CITY OF ALBUQUERQUE

Re: La Resolana Apartments, 1025 Chelwood Park Boulevard NE,
Traffic Circulation Layout
Engineer's Stamp dated 10-07-09 (J22-D017)

**Re: La Resolana Apartments, 1025 Chelwood Park Boulevard NE,
Traffic Circulation Layout
Engineer's Stamp dated 08-21-09 (J22-D017)**

Re: La Resolana Apartments Grading and Drainage Plan
Engineer's Stamp date 8-21-09 (J22/D017)

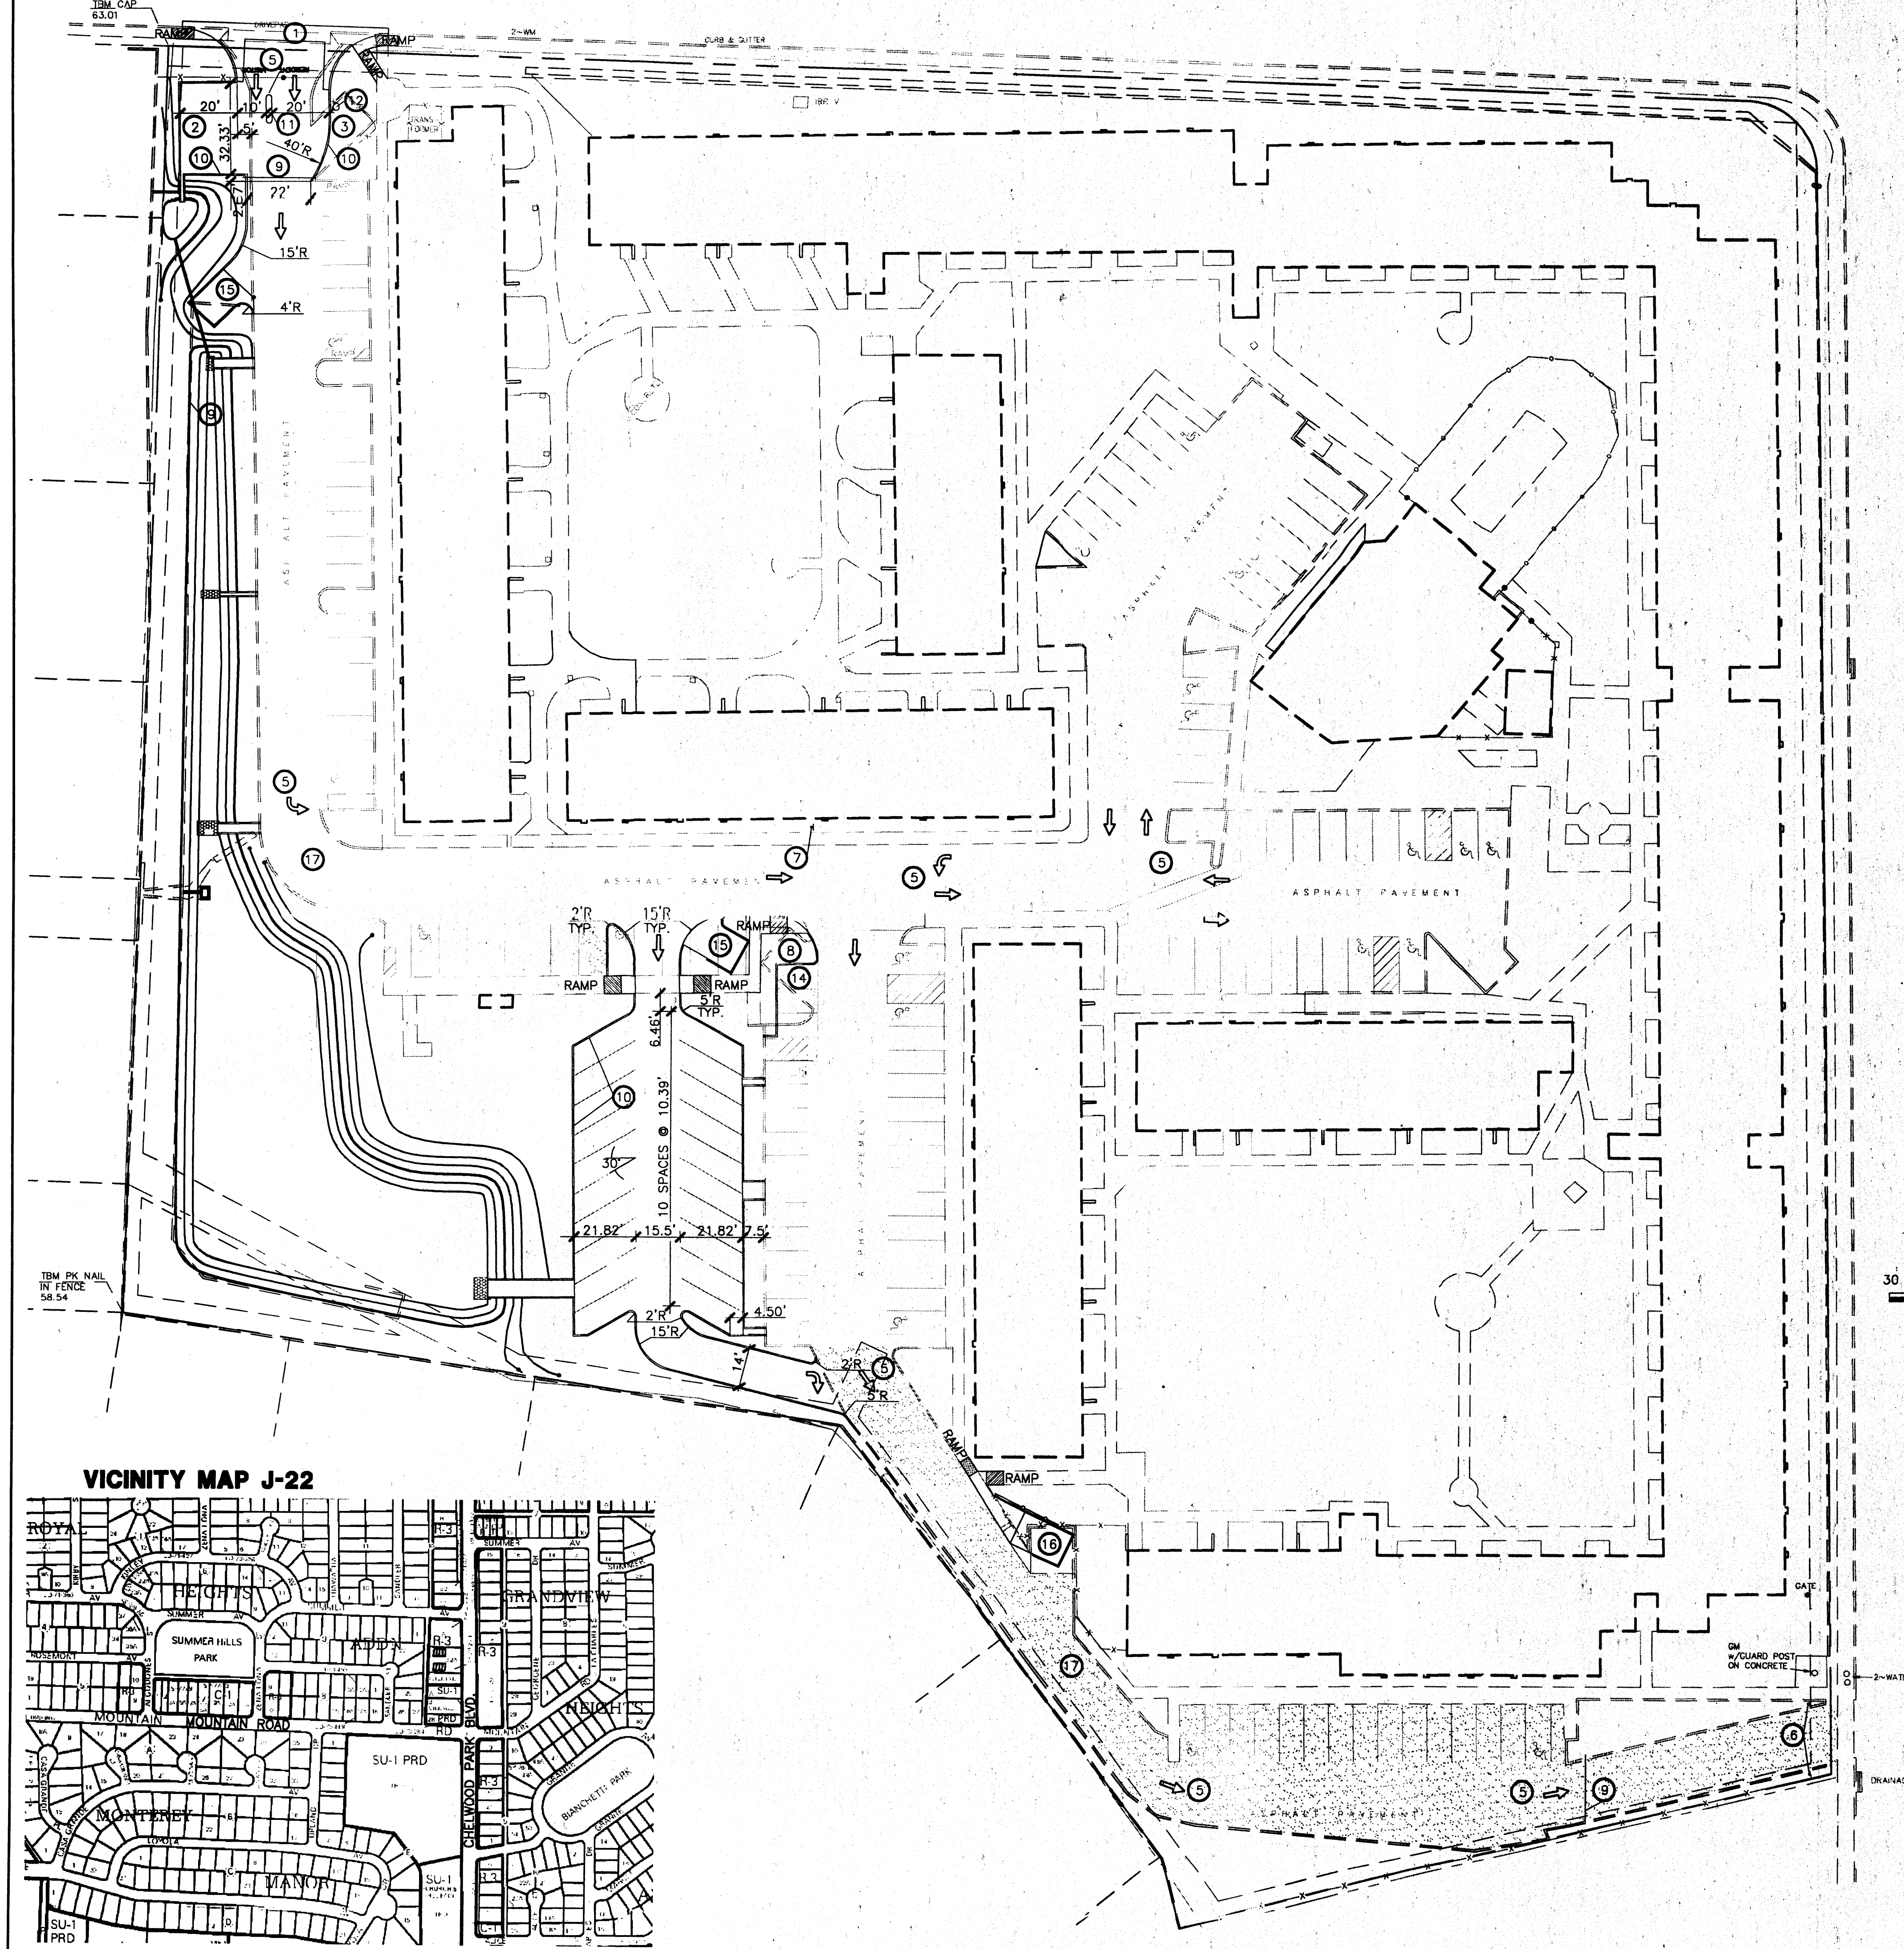
- ~~1. List the width and length for all parking spaces.~~
2. Please show a vicinity map.
- ~~3. List the number of parking spaces required by the zoning code as well as the proposed number of parking spaces.~~
4. Please include two copies of the traffic circulation layout at the next submittal.
5. Clarify how the two-directional traffic transitions to one-directional traffic. Additional striping and / or signing may be required.
6. Provide details for all wheelchair ramps; define the maximum slope.
- ~~7. Define the angle of the one-directional parking spaces.~~
8. Call out the width of all sidewalk.
9. Provide additional information about the proposed gate.
